**From:** Erin Moore  
**Sent:** Friday, July 05, 2013 1:01 PM  
**To:** Jeff Watson  
**Subject:** FW: BL-13-00015 Haybrook

**From:** Jeff Watson  
**Sent:** Wednesday, July 03, 2013 12:15 PM  
**To:** Christina Wollman; Brenda Larsen; Jan Ollivier; Holly Duncan; Erin Moore  
**Subject:** BL-13-00015 Haybrook

PROPOSED

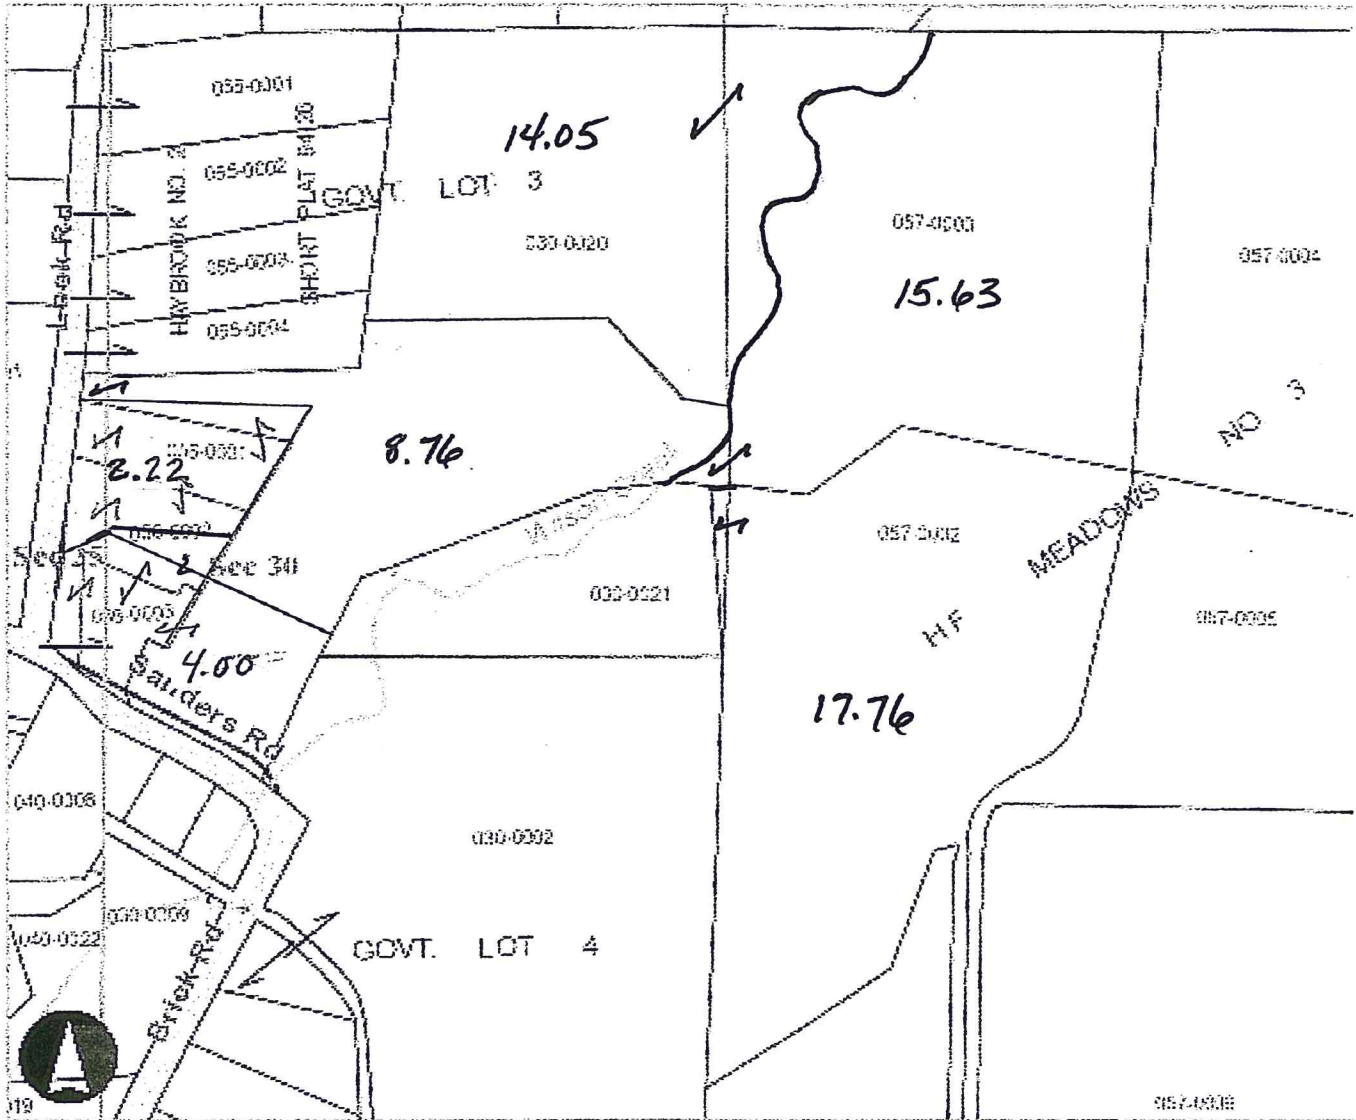
The proposed lines don't appear to be within 50 feet of any existing wells. This should be alright.
